**WELWYN HATFIELD BOROUGH COUNCIL
EXECUTIVE DIRECTOR - PLANNING, PUBLIC PROTECTION AND GOVERNANCE**

DELEGATED APPLICATION

Application No: 6/2020/1708/HOUSE
Location: 93 Bramble Road Hatfield AL10 9SB
Proposal: Erection of part single, part two storey side and rear extension, erection of front porch, conversion of existing and proposed roof spaces to facilitate a rear dormer and roof light. Re-tiling of roof and demolition of existing garage and workshop.
Officer: Mr Raymond Lee

Recommendation: Granted

date	scale	drawn
April 2020.	1:100@A2	dbd
drawing number	sheet no.	rev.
203/PA/003.		B

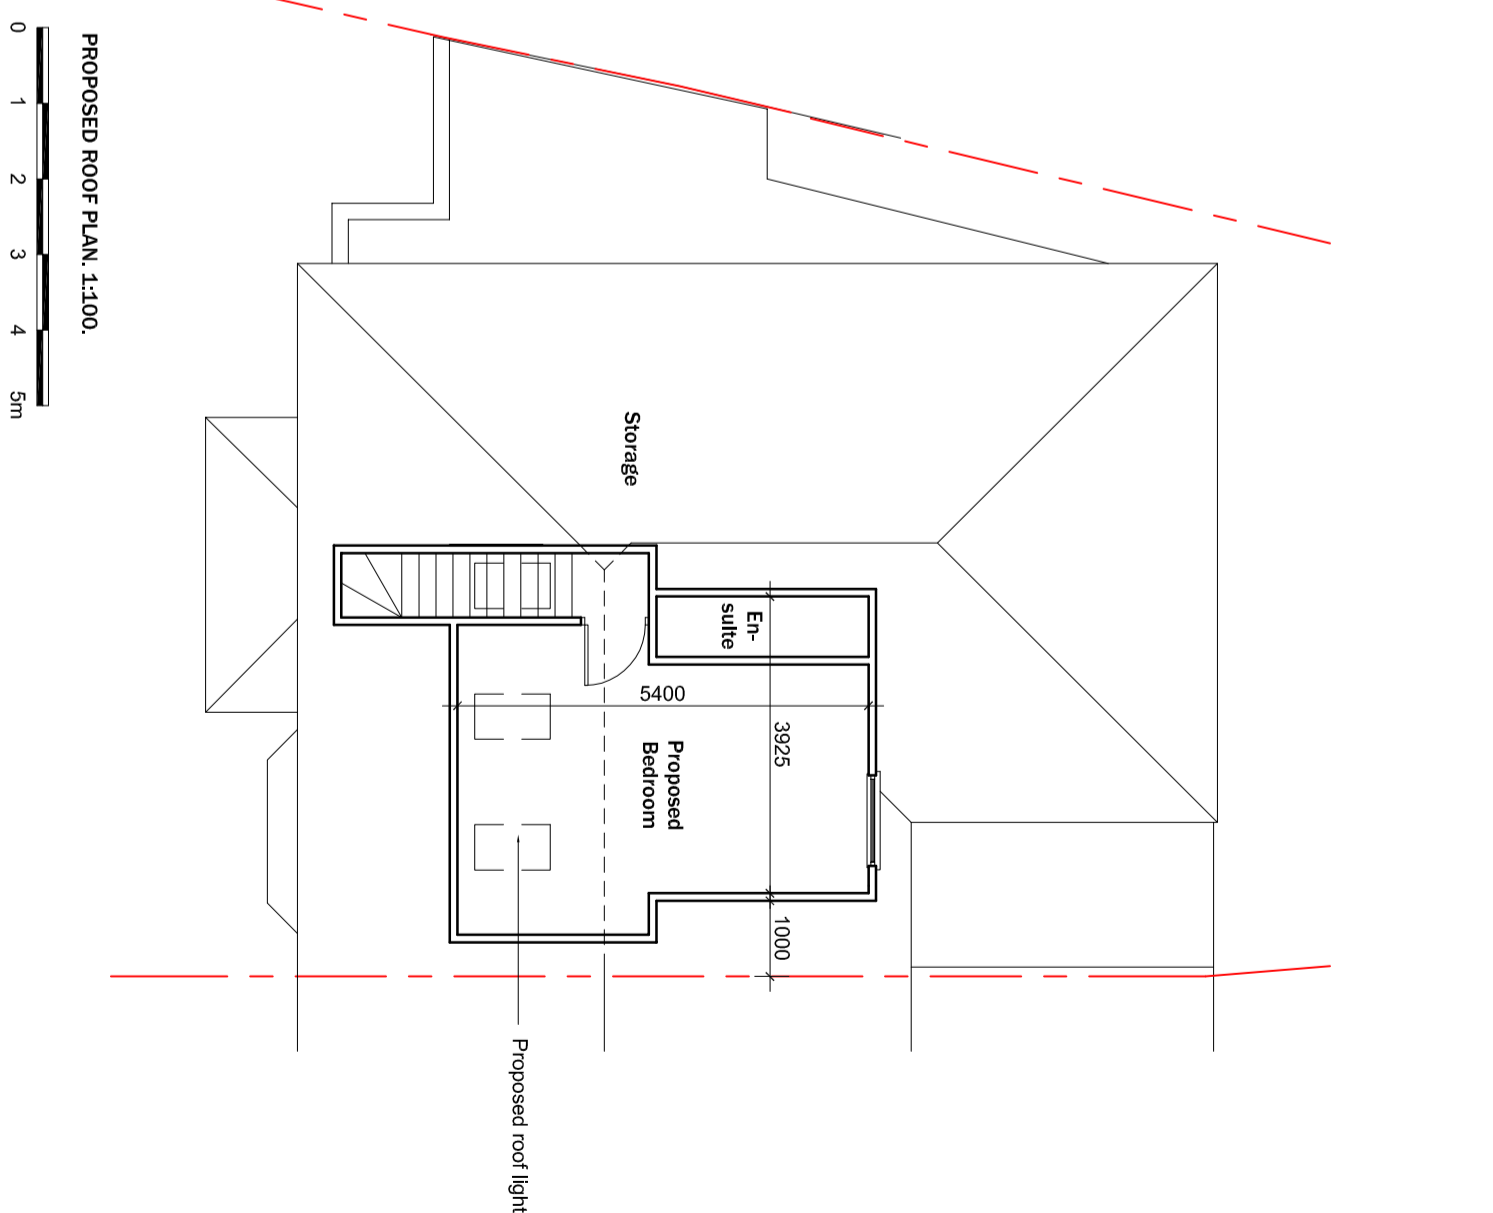
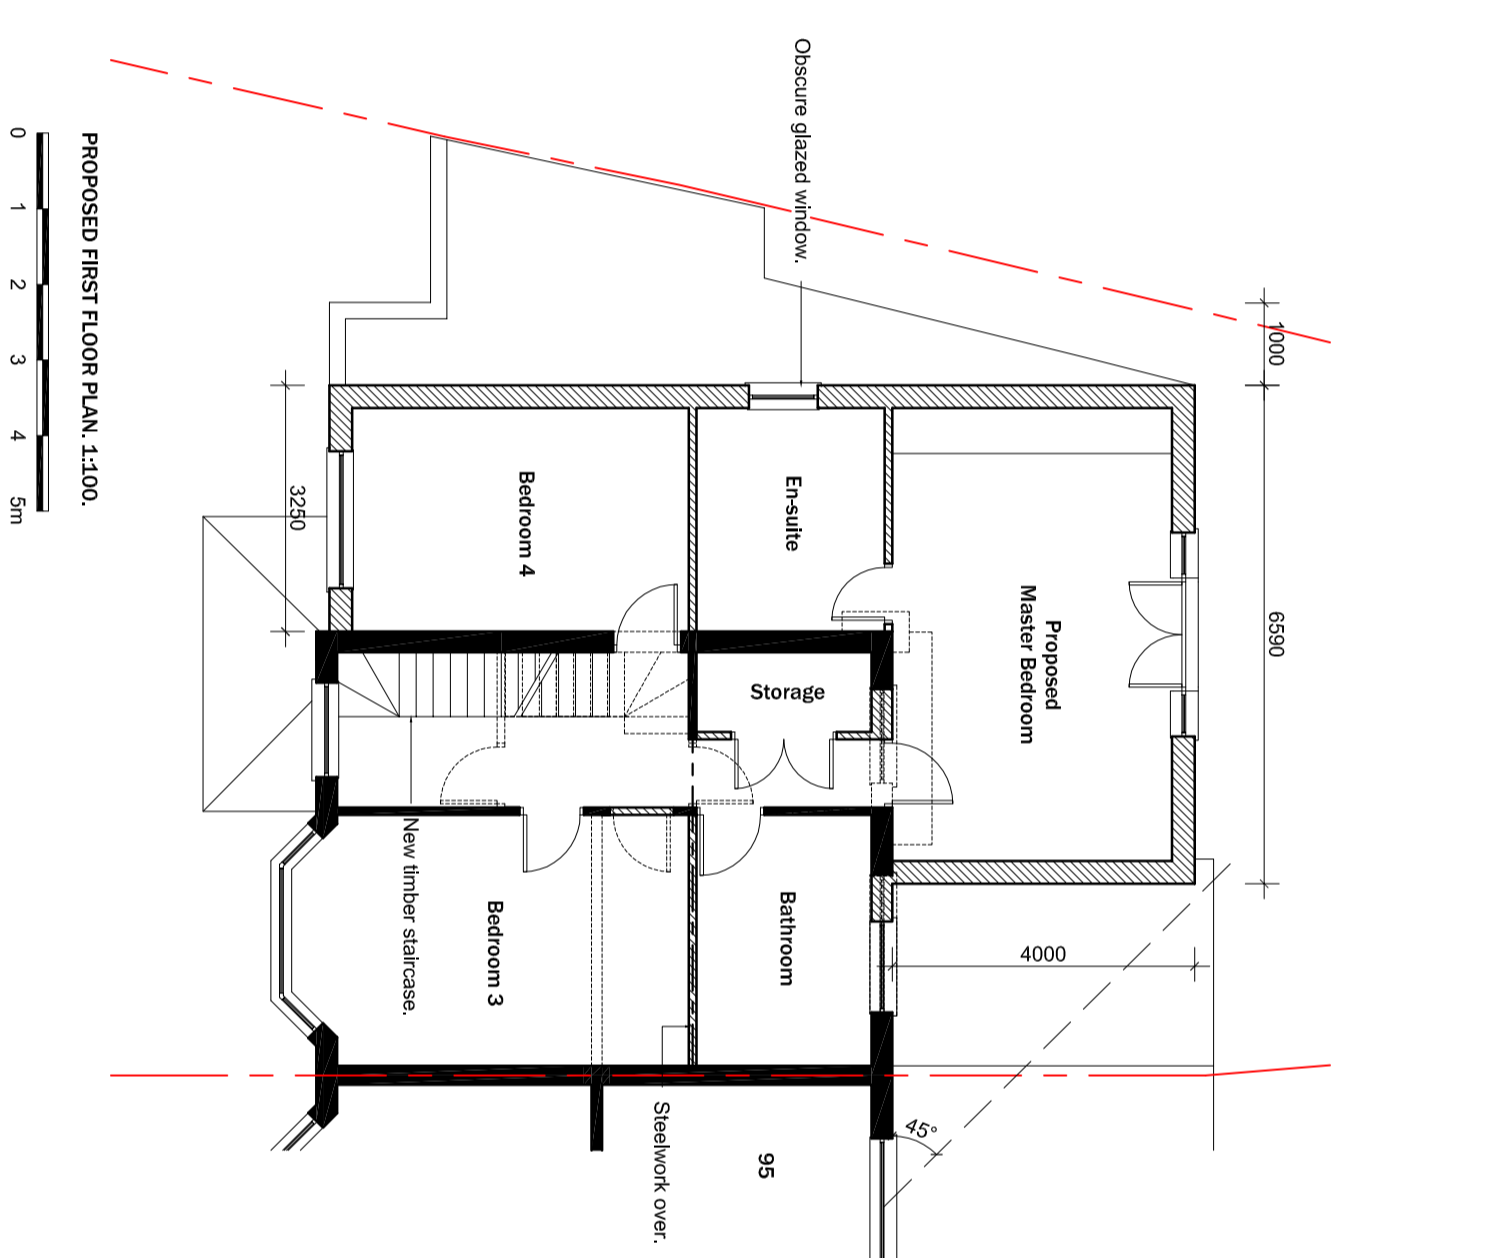
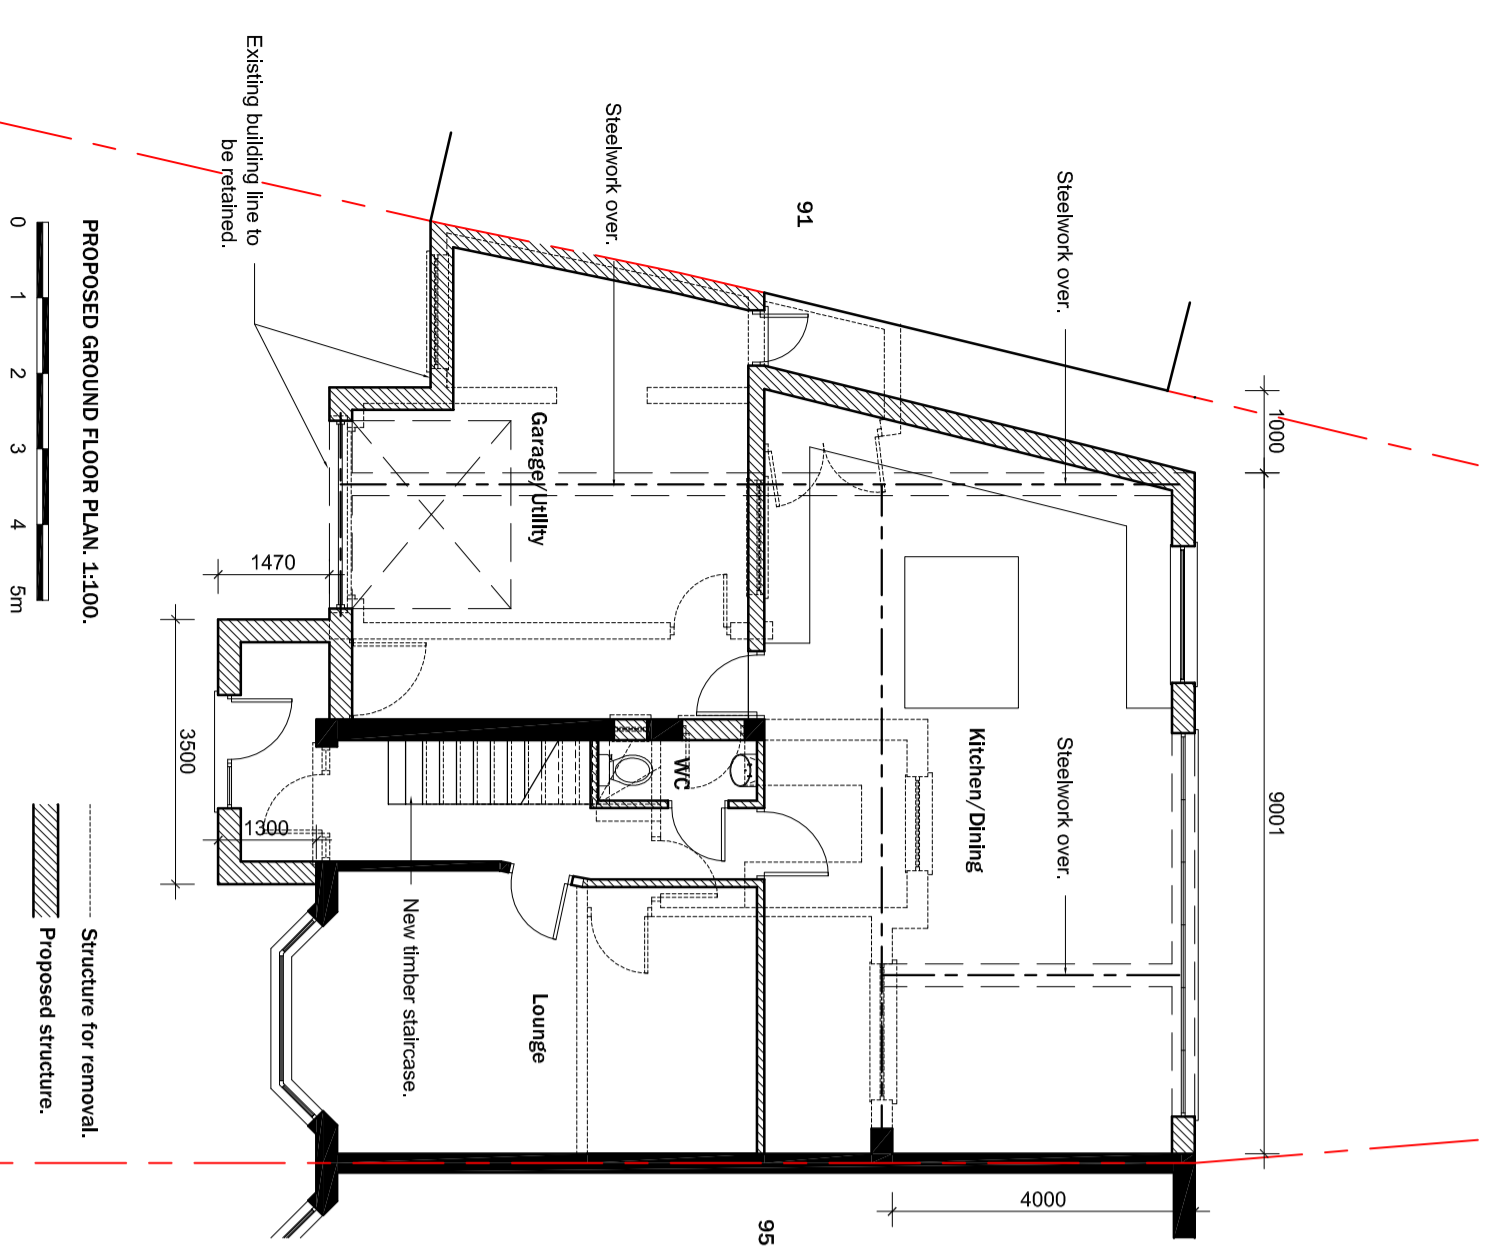
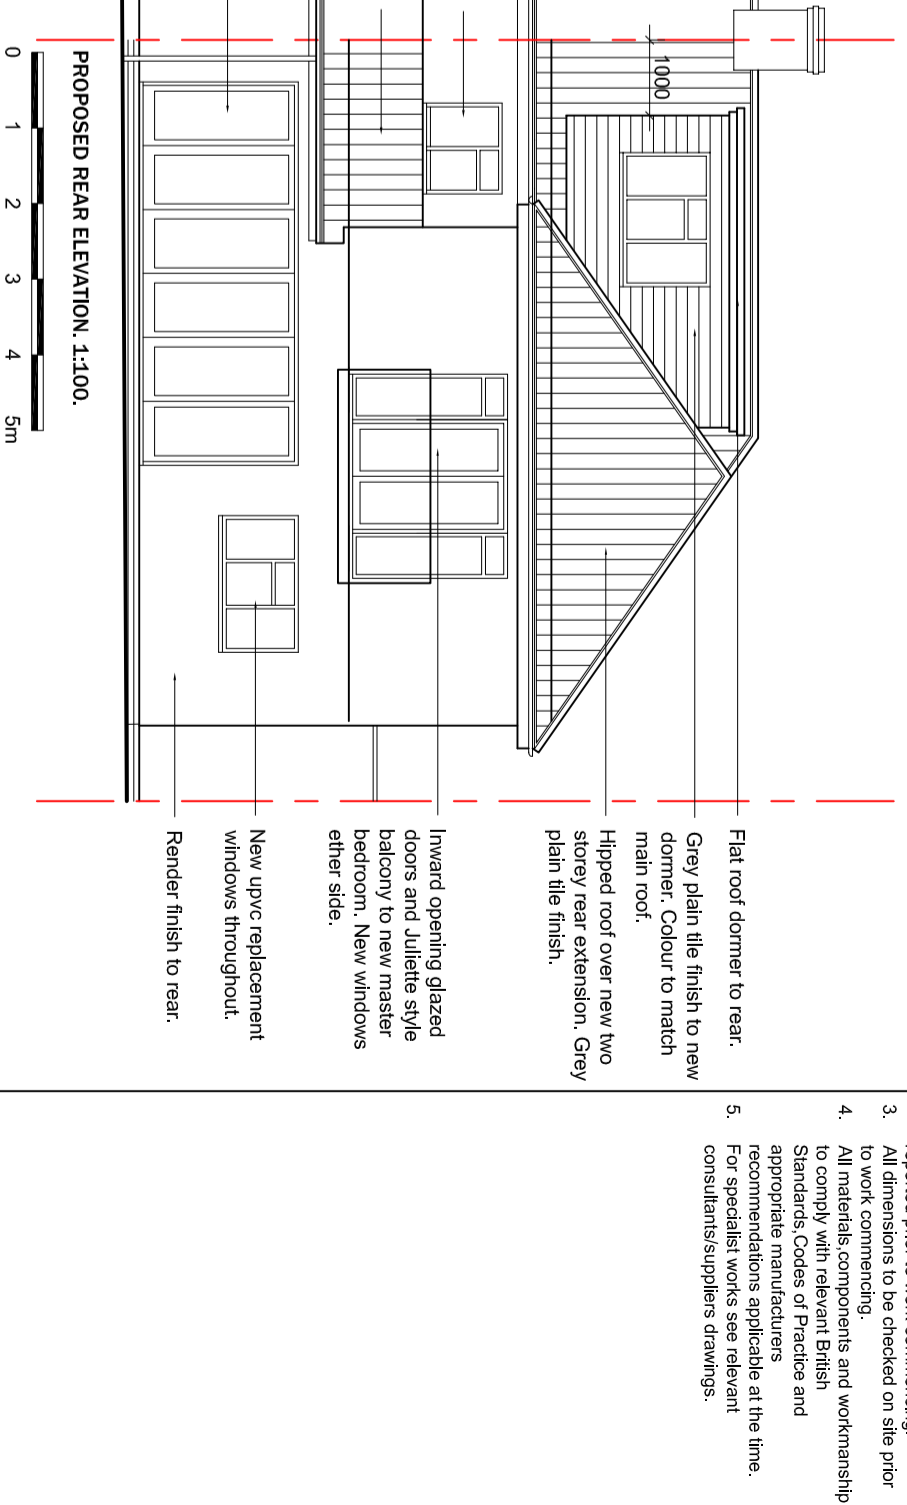
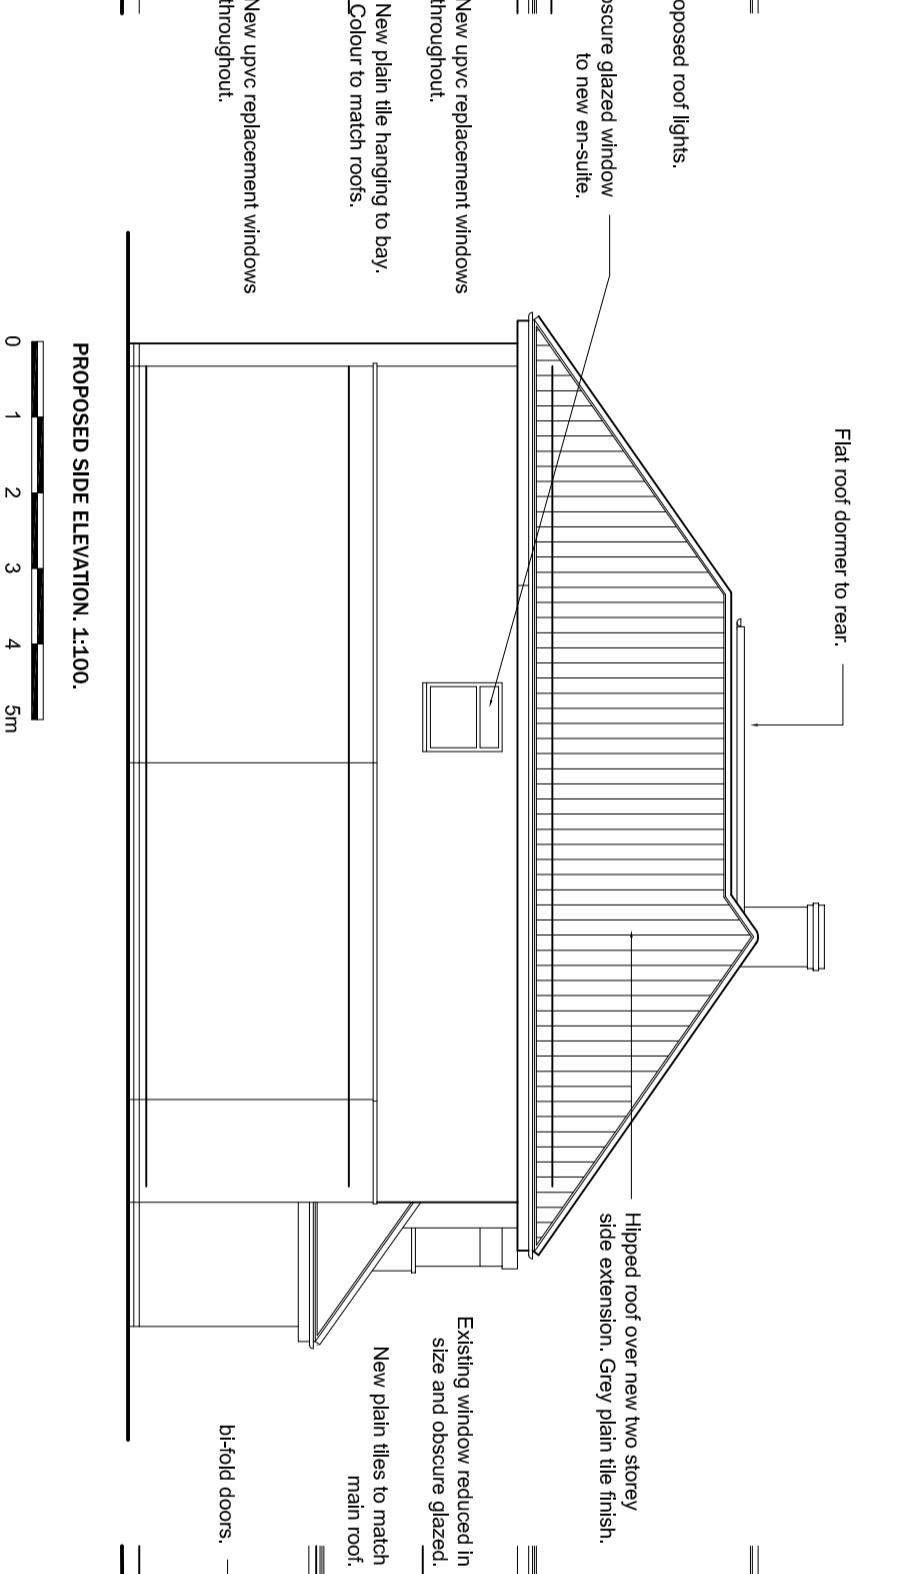
<p>Whilst cumulatively the proposed extensions are substantial in size and scale compared to the original building, it is important to note that numerous dwellings in the immediate locality have been extended in a similar fashion to the proposed development. Examples include numbers: 3, 5, 8, 44, 56, 58, 66, 95, 97, 111 & 113 Bramble Road. As such character of the street has evolved over time where sizeable extensions are commonplace.</p>	
<p>The two storey side extension would step back marginally from the front building line and the follow the existing hipped roof design. This element would also be set in from the common boundary at first floor level and above by 3.5 metres at the front and a minimum of 1 metre at the narrowest point, which is in line with the Council's SDG and in keeping with other side extensions in the area.</p>	
<p>The two storey rear extension would have a hipped roof and is appropriately set down from the main ridge and its depth at 4 metres is just over half the depth of the original house. Furthermore, this part of the scheme would be suitably set in from the party wall with No. 95 Bramble Road at first floor by approximately 2.5 metres to aid in reducing the bulk and massing of the extension at first floor level,</p>

resulting in an addition that would appear subordinate to the rear of the building. The dwelling would retain a large amenity area to the rear as such the resultant dwelling would not appear cramped or contrived within its plot.

The rear box dormer has been set in from the shared boundary by approximately 1 metre as per the adopted guidance and will be lower than the main ridgeline. Whilst the relationship between the rear dormer and roof of the two storey addition is not considered to be of high quality design, it would be largely concealed from the public realm behind the proposed two storey rear and side extension. As such the impact on the street scene is limited. Consideration has also been given to the fact that there are permitted development rights that would allow for development of a similar scale and appearance on the existing building.

The single storey porch extension to the front would appear as a simple and modest addition to the principle elevation with a hipped roof form to match the main property. This part of the proposal would therefore have limited harm to the character of the street scene.

In terms of materials, it is proposed to change the current brown clay roof tiles to grey concrete tiles for both the extensions and main dwelling. Whilst this is a departure from the existing, there is already a significant degree of variation in the colour and style of roof tiles being used in the surrounding area with Nos. 45 and 66 having similar grey concrete tiles. A change from brown to grey tiles would not normally be acceptable for a semi-detached property due to the resulting contrast, however, in this case the resultant dwelling would not appear out of keeping with, or detrimental to, the evolving character of the area. A condition is suggested to ensure the tiles match the existing in terms of their size and do not contrast unacceptably with other tiles in the area. The walls will be finished in render throughout which is in keeping with the original house. The proposed windows will be finished in grey uPVC throughout to replace the existing units which are in white. Again, there are other examples of grey windows in the area so this would be acceptable in this case. Subject to sample of materials being submitted and approved prior to development above ground level, the proposal is considered to be acceptable.

This neighbour is located immediately to the north-west of the application site. As a result of the orientation of the rear extension, the hipped roof proposed and its distance to the common boundary at 2.5 metres, the levels of daylight/sunlight received by this neighbour at their main amenity areas would not be significantly affected. The extension is shown to pass the 45 degree light test on both plan and elevation for their first floor bedroom window. Similarly the proposals would not appear unduly dominant from their main amenity areas as the extension would project no further than their rear building line and the first floor element of the scheme has been hipped and set away from their boundary. In terms of privacy, there are two bedroom windows on the existing building that already have an outlook onto their garden. It is considered that the proposed rearward facing openings would not afford any significant views over and above that of the existing units to warrant a refusal. The proposed Juliet balcony by design does not afford a stepping platform therefore it does not raise any additional concerns relating to privacy than if windows were proposed at the same location.

2. The side facing en suite bathroom window on the south-east elevation of the development hereby approved must be obscure-glazed and non-opening unless the parts of the window which can be opened are more than 1.7 metres above the floor of the room in which the window is installed, and shall be retained in that form thereafter.
